KITTITAS COUNTY

MEMORANDUM

TO: Kaycee Hathaway, Community Development Services
FROM: Kelly Bacon, Engineer Technician I *KB*
DATE: August 24, 2017
SUBJECT: Conner BL-17-00013

**SHEET 1 OF 3**

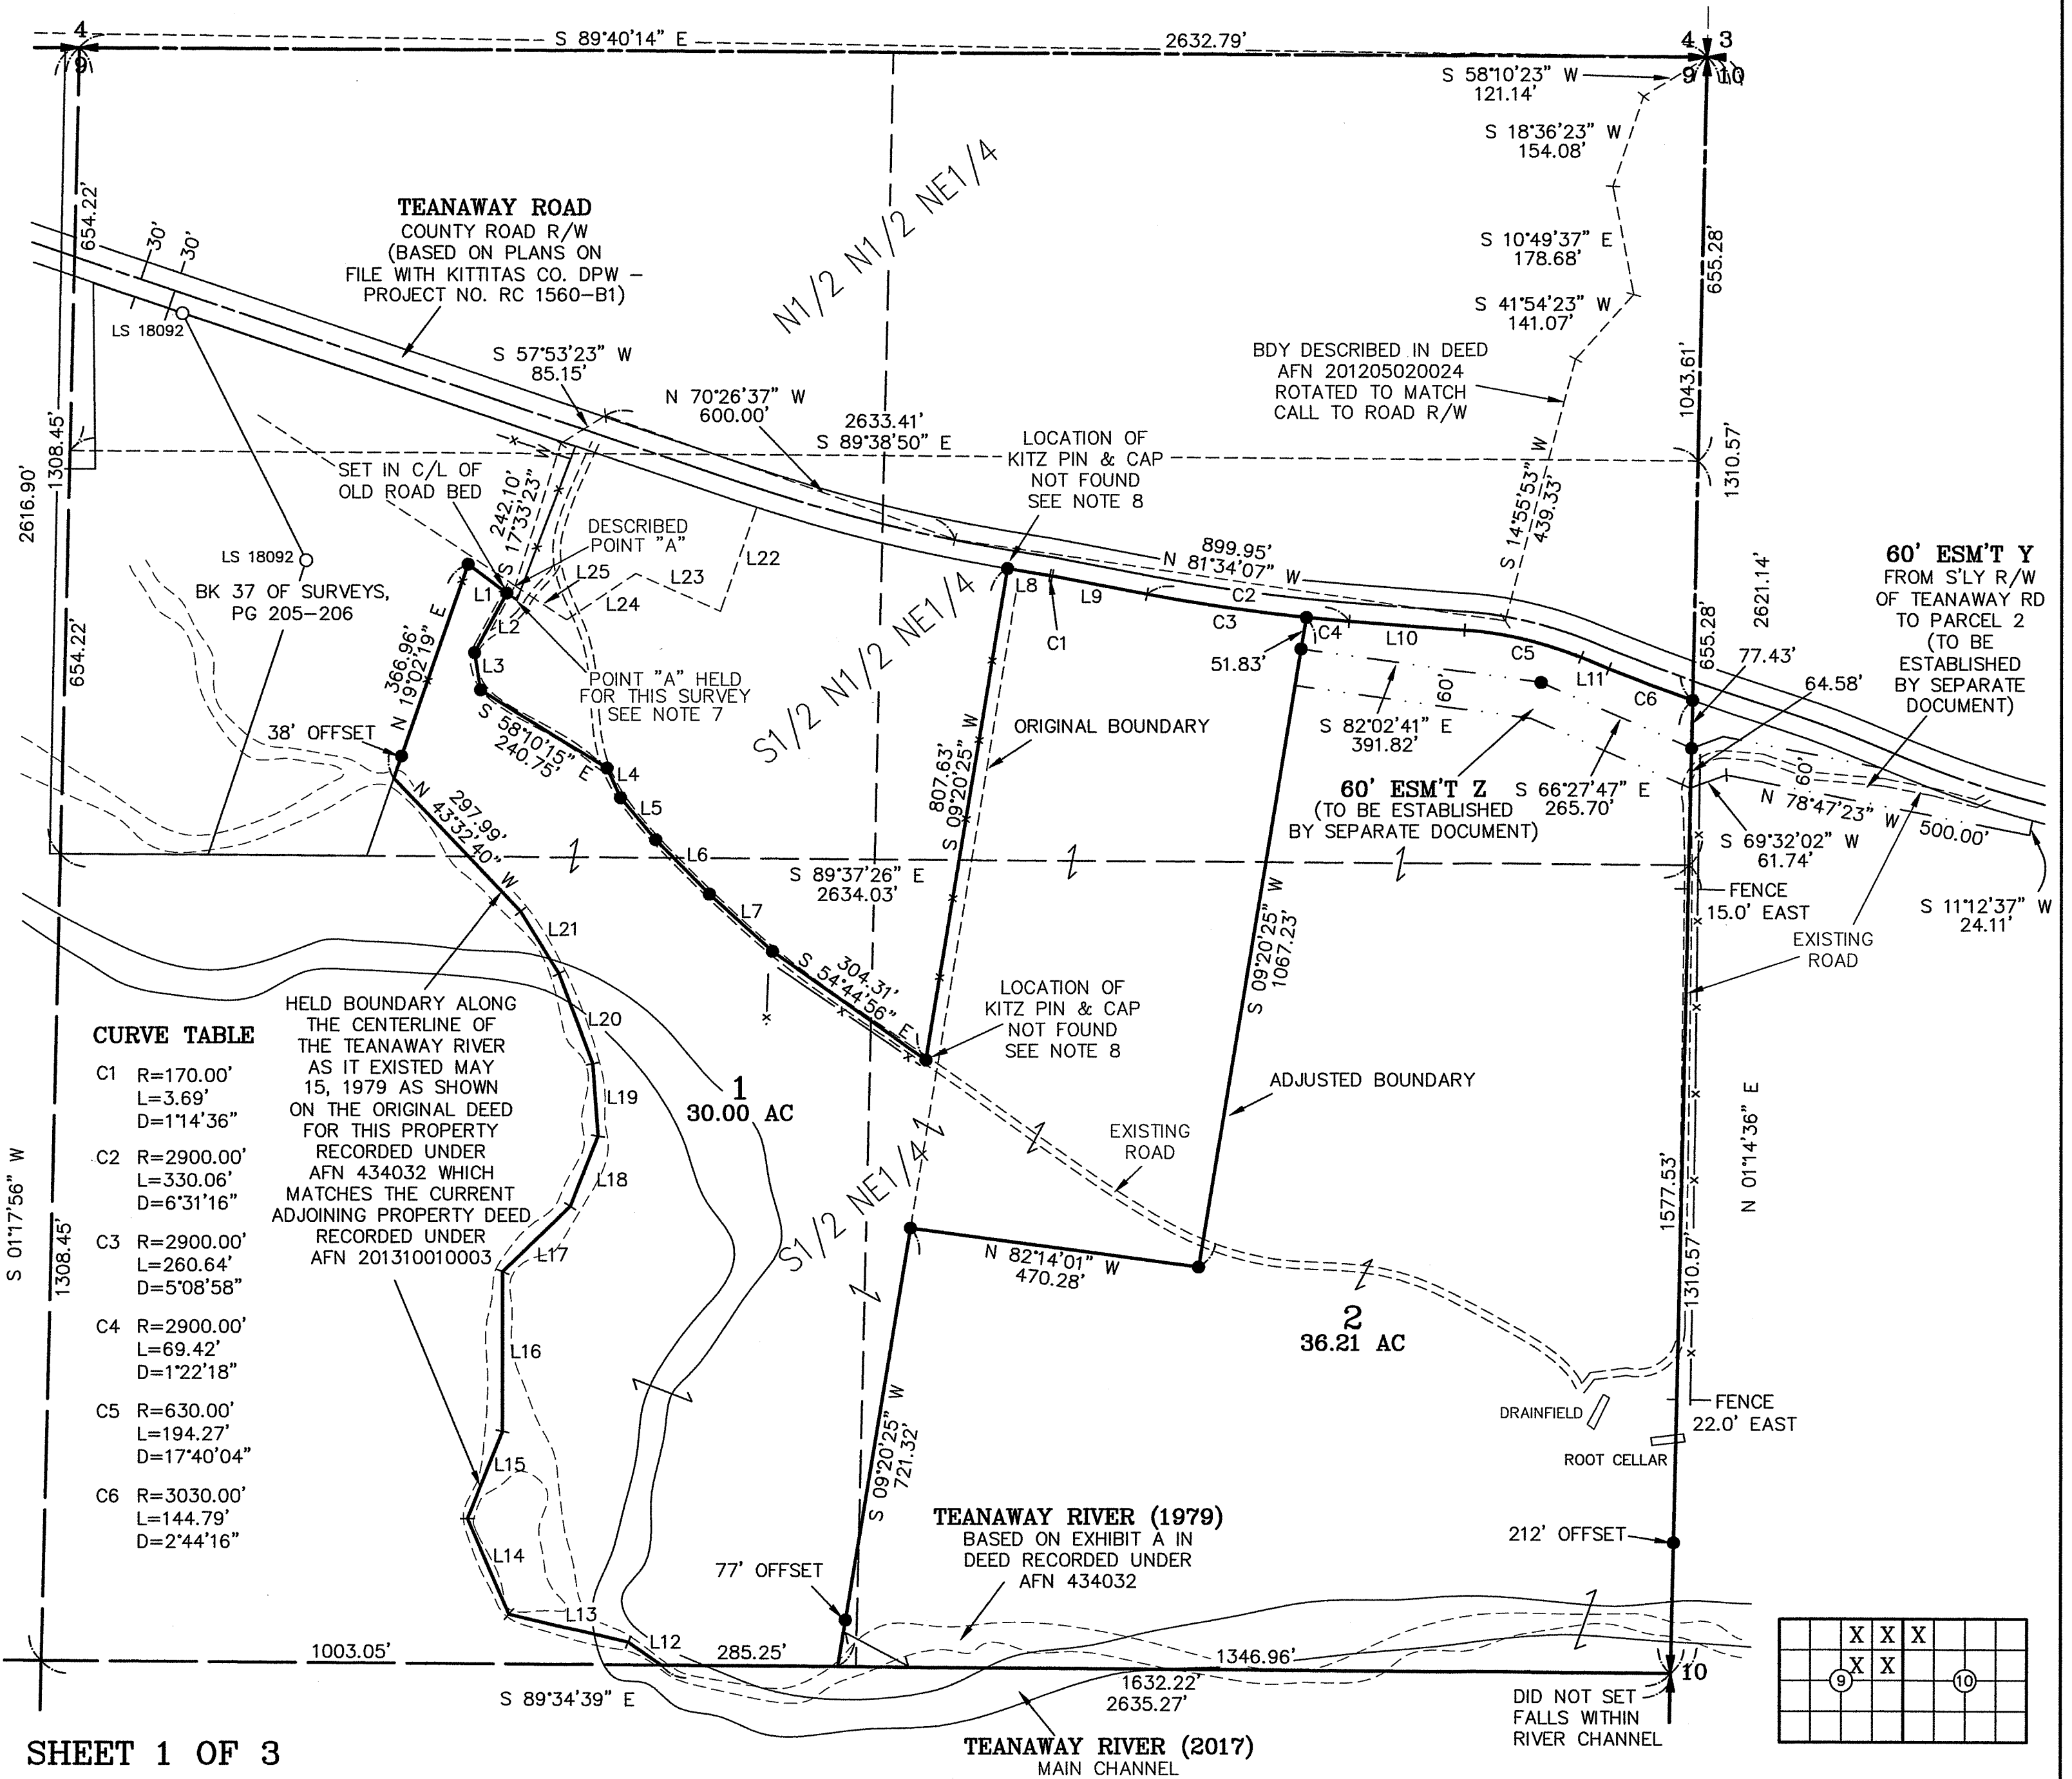
1. A revised legal description that describes the final configuration of the subject property shall be required.
2. A survey map for review
3. Show access easements on the face of the BLA
